ALBUQUERQUE MEMORY CARE FACILITY

Re: DRB Submission - Description and Justification Statement
Albuquerque Memory Care Facility / 8101 Palomas Ave NE

RE: Project #1008527
10EPC – 40060 Site Development Plan for Building Permit

FILE: **Project # 1008527**
10EPC-40060 SITE DEVELOPMENT
PLAN FOR BUILDING PERMIT

# Site Plan

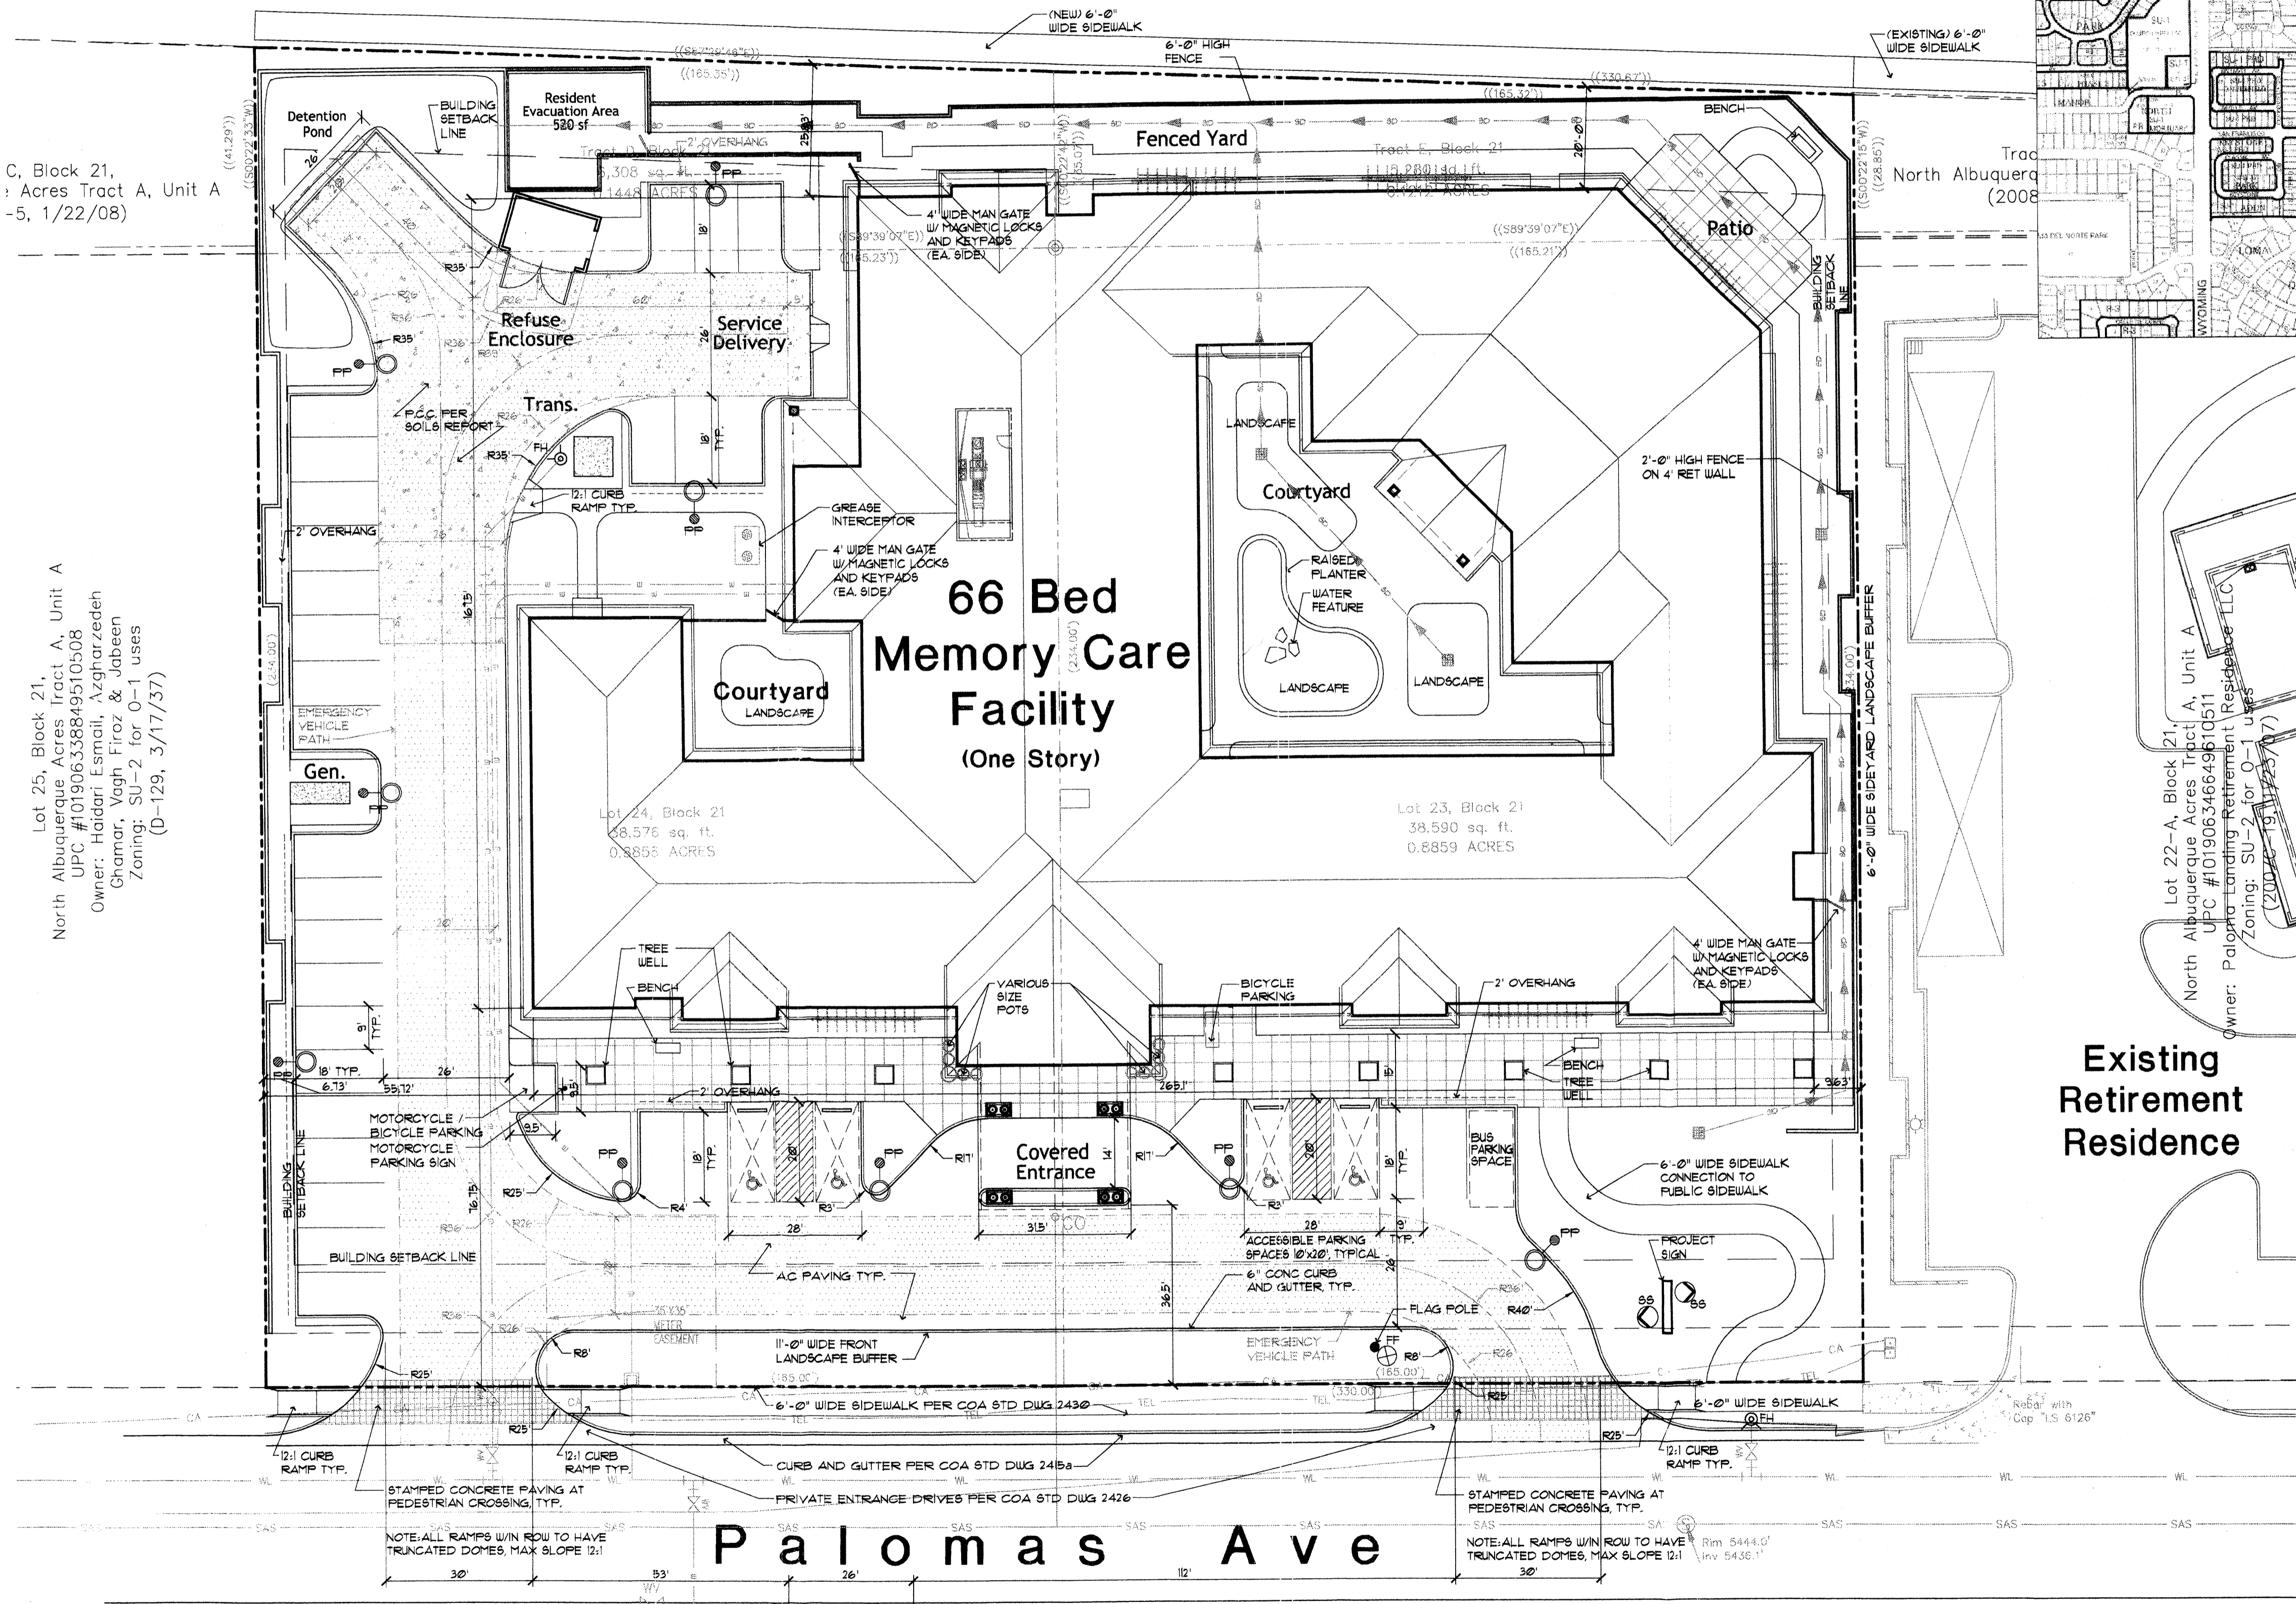
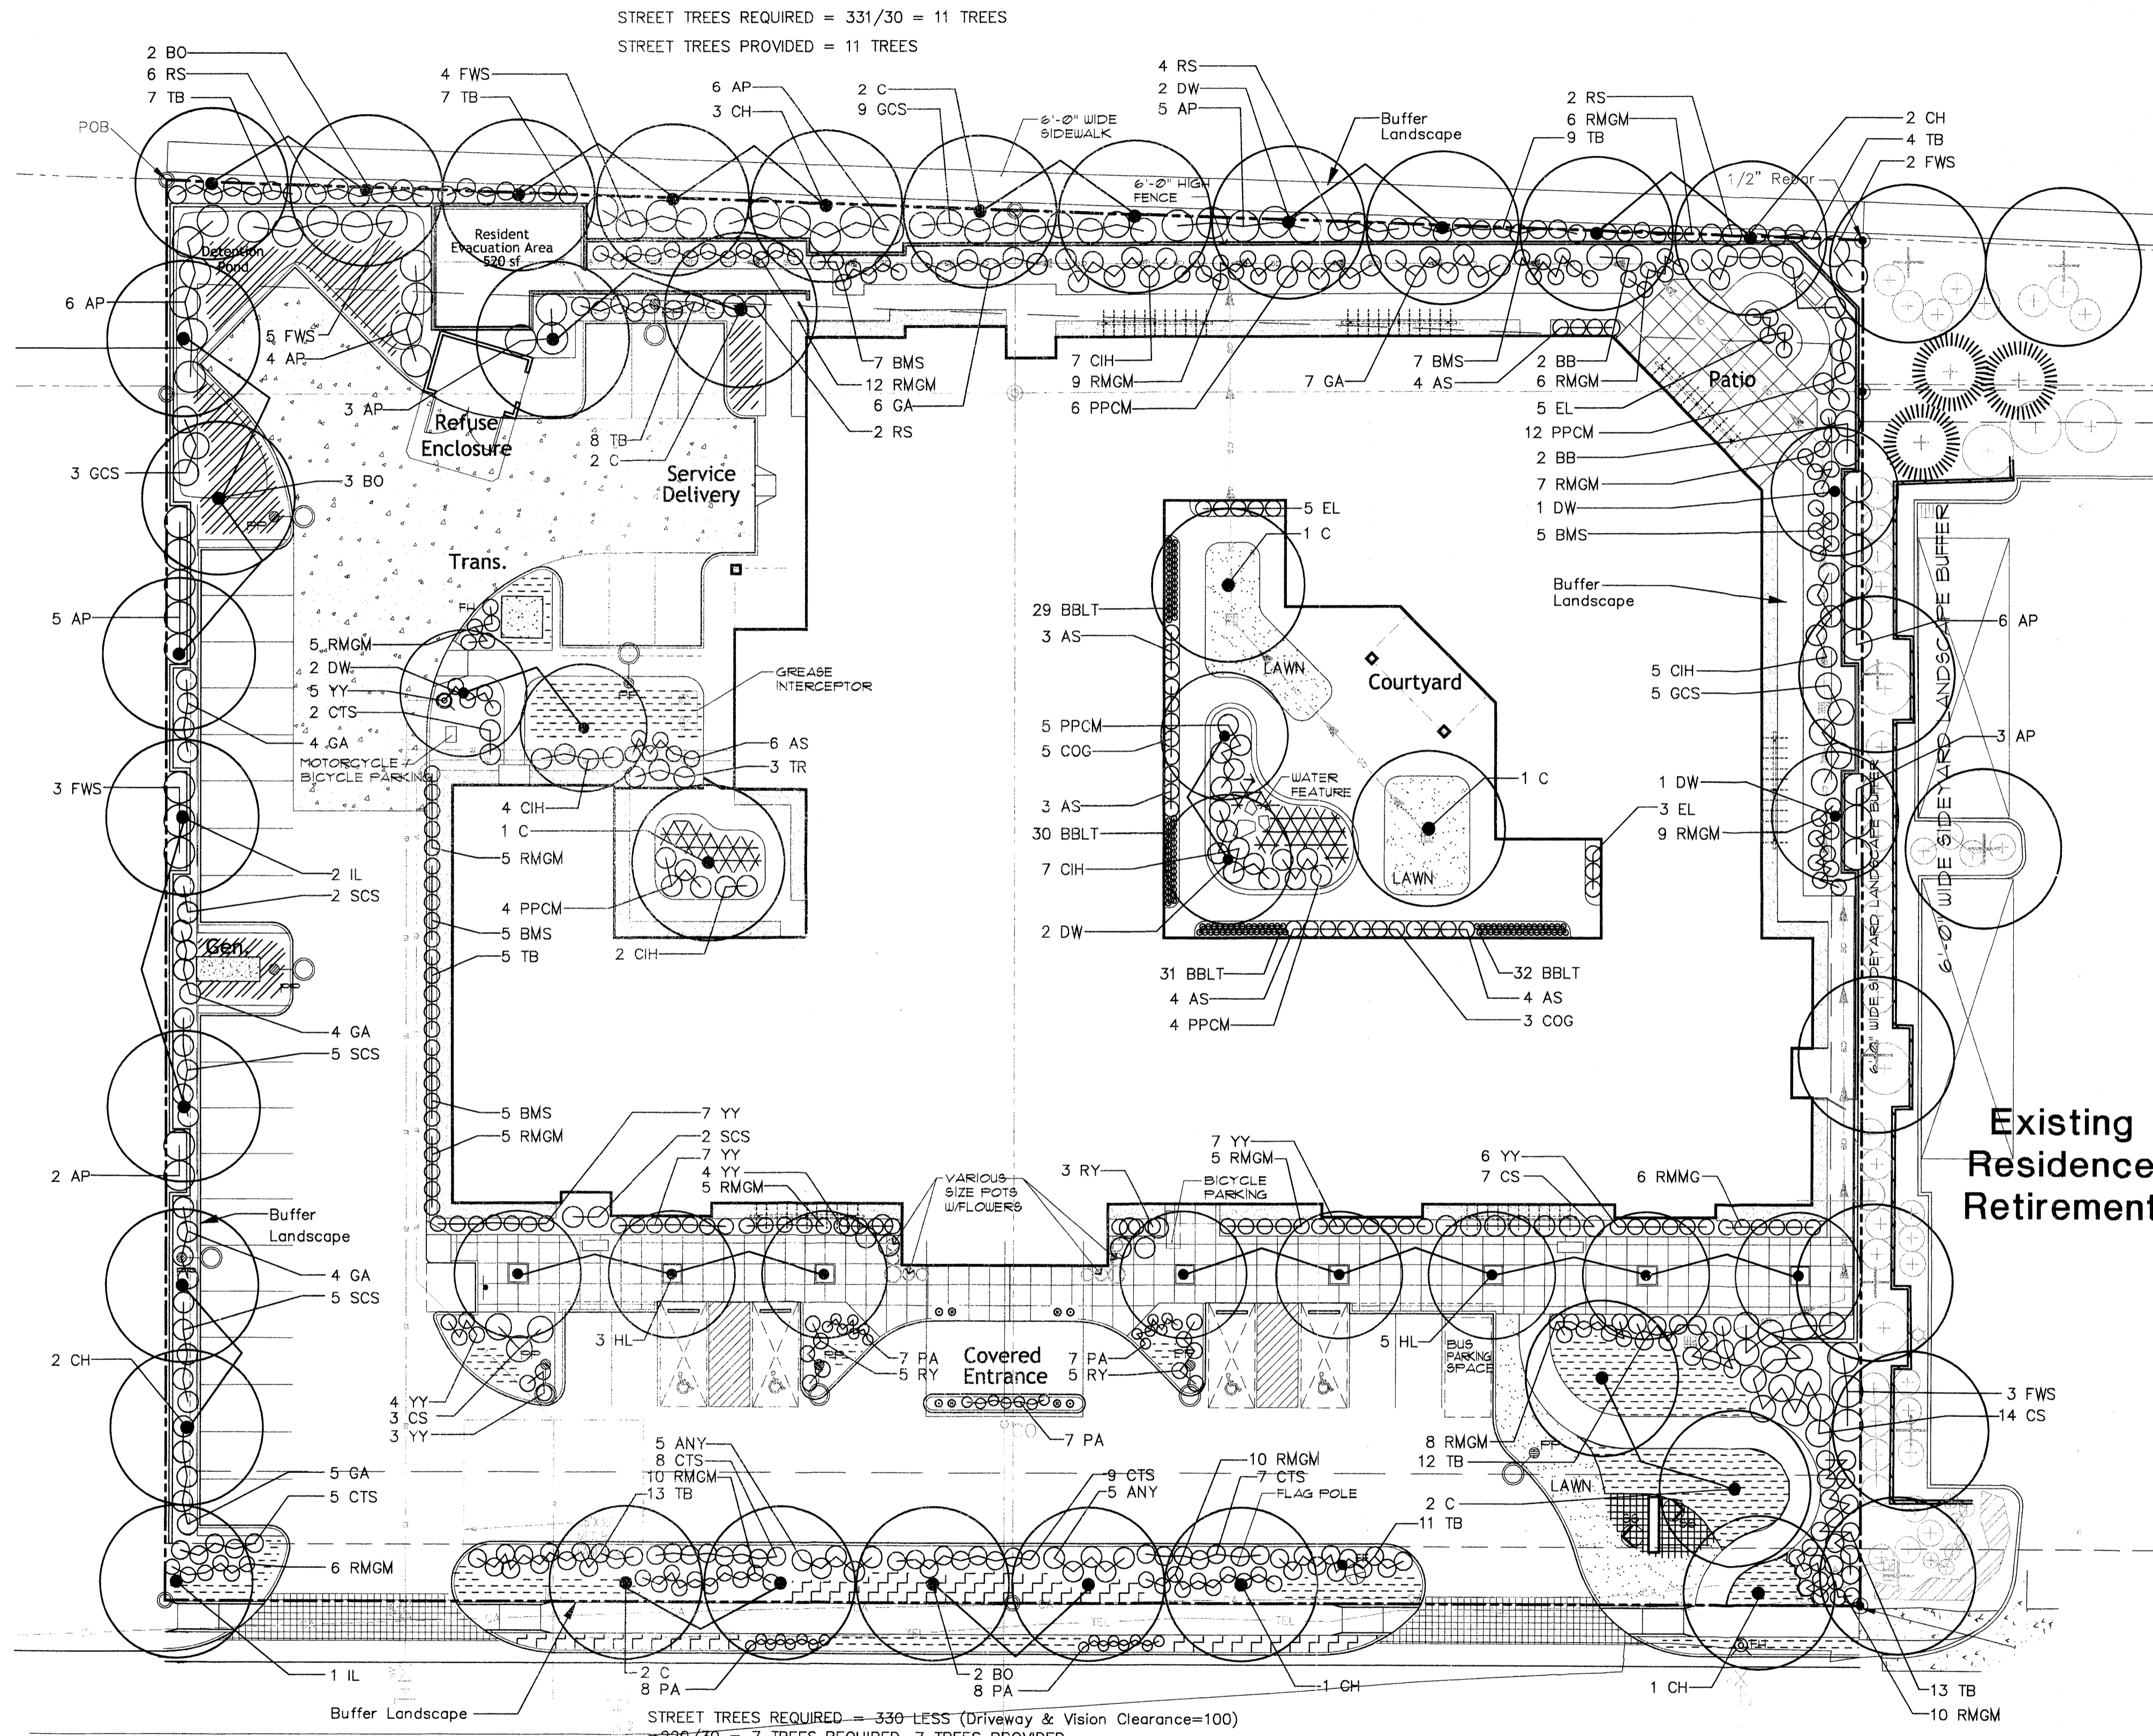
3. The applicant shall provide a 2' overhang for all parking spaces.

4. The word "open" shall be deleted from the parking calculations in the site plan so as not to confuse it with "open space" as defined in the Zoning Code.

5. The Motorcycle parking spaces shall move to a visual site of the front entrance of the building and the signage shall be shown on the site plan's details of what will be provided.

6. The applicant shall provide a 15' wide sidewalk in front of the building's front facade for the length of the facade unless granted a variance by the Zoning Hearing Examiner for a sidewalk that is no less than 8-feet wide. Shading and seating shall be provided along this sidewalk.

7. The applicant shall continue the sidewalk/trail on the north side of the site for the portion adjacent to the site.

b. Provide dimensioned distance between site drives as measured from face of curb to face of curb.

c. Provide turning template information at site drives for rescue vehicles entering from Palomas that will need to access the front entrance.

d. Dumpster enclosure location, as shown, will not allow solid waste vehicles to maneuver on-site. Approval from solid waste required.

e. Define area of rescue assistance.

f. Disabled parking spaces need to be 20' in length.

See revised site plan for a 2' overhand for all parking spaces.

See revised site plan, "open" has been replaced with "regular".

See revised site plan, motorcycle spaces have been relocated and signage details provided.

See revised site plan, 15' sidewalk has been added.

See revised site plan for continuation of the north property line sidewalk.

See revised site plan for site drive dimensions.

See revised site plan for turning radii with centerlines.

Plans reviewed by Solid Waste and approved.

See revised site plan, area of rescue assistance has been relabeled as "Resident Evacuation Area".

See revised site plan for 20' disabled spaces.

**PARKING LIGHT TYPE PP**

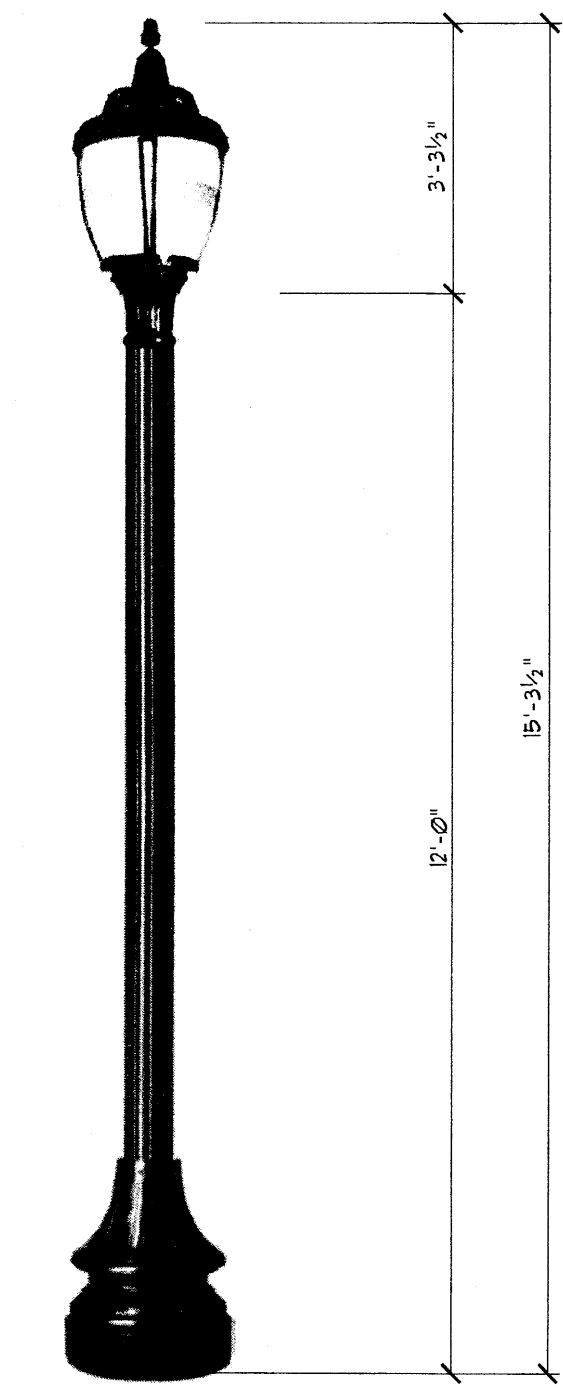
8. All lighting fixtures shall be shielded and in compliance with the La Cueva Sector Development Plan and the Zoning Code and noted on the site plan.

See revised site plan for compliance statement.

# EXTERIOR ELEVATIONS

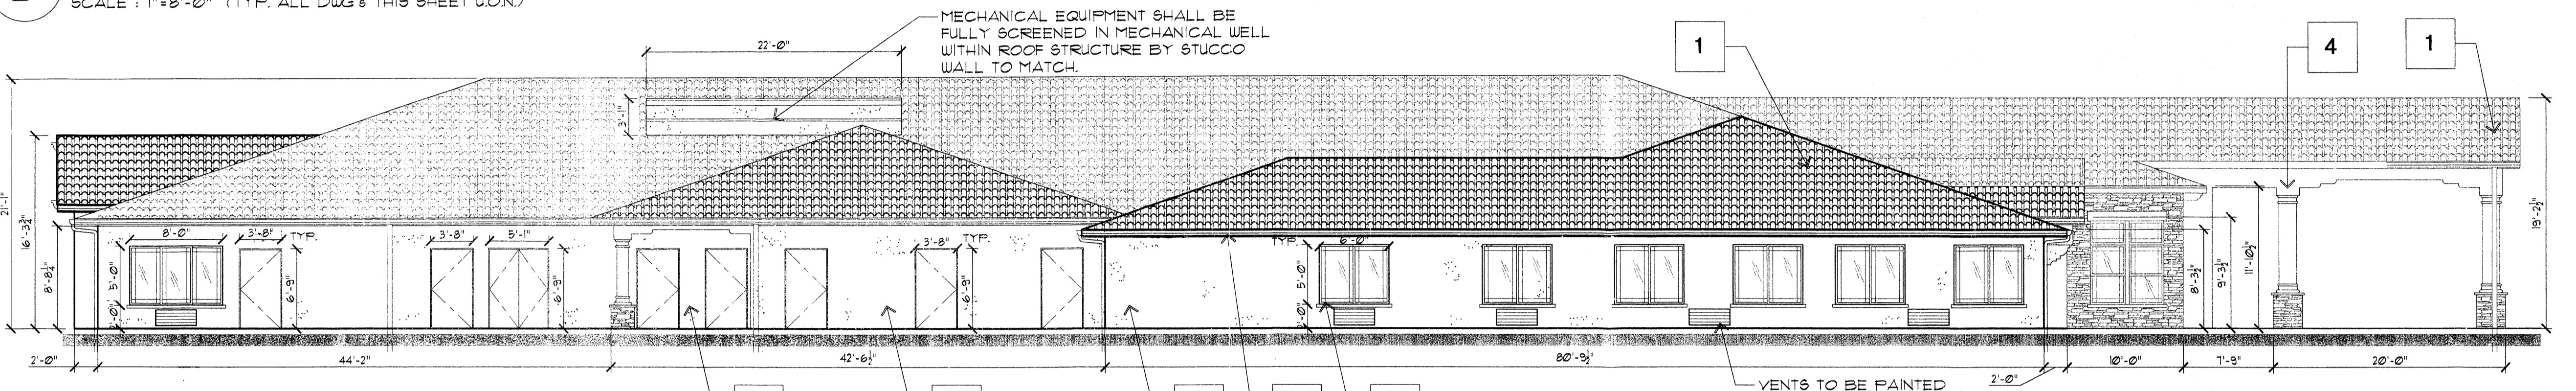
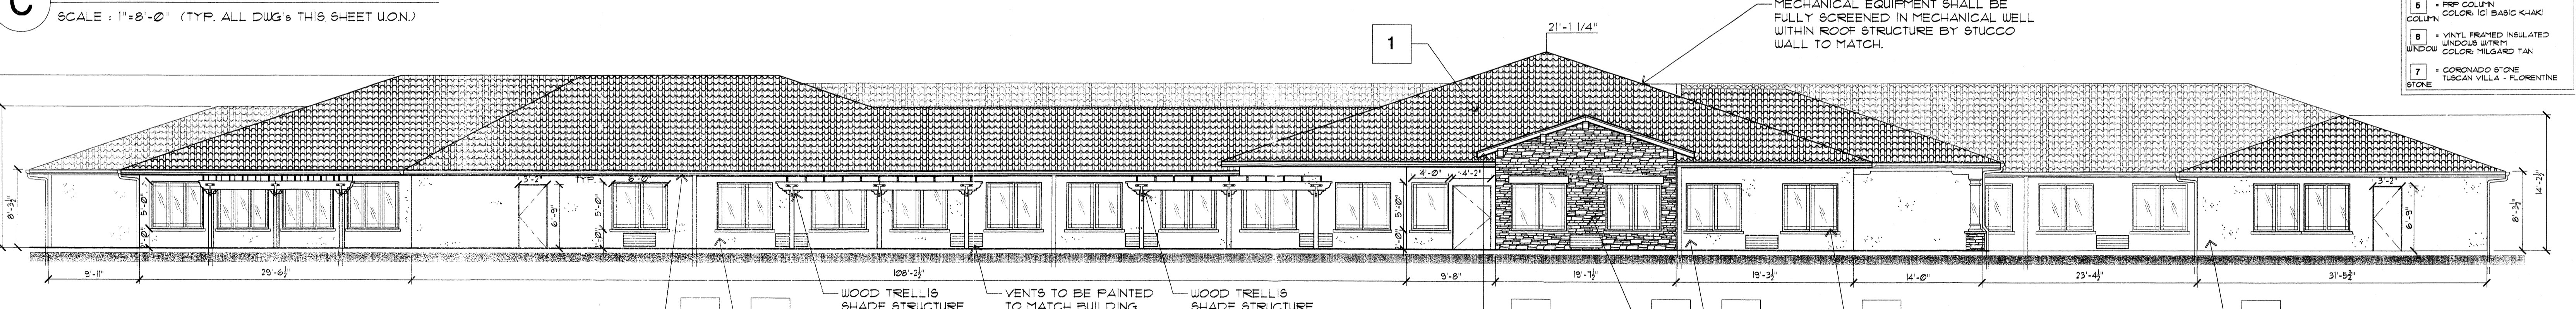
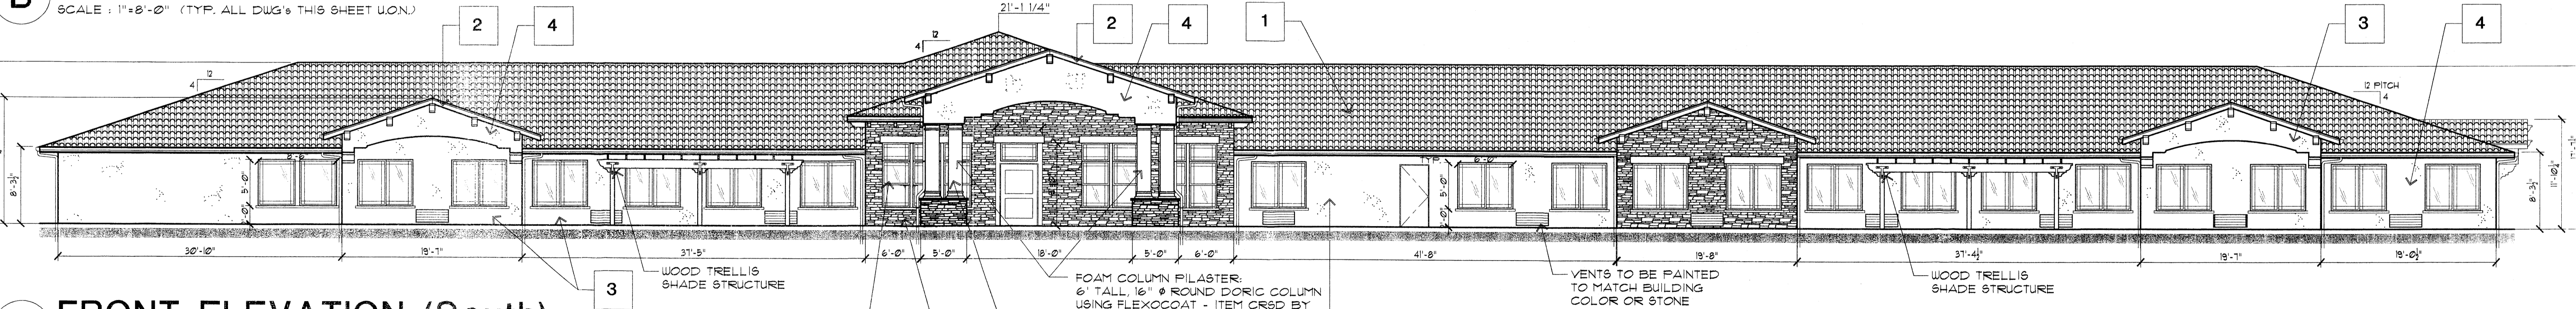
12. Stacked stone may be provided on the north elevation.

So noted.
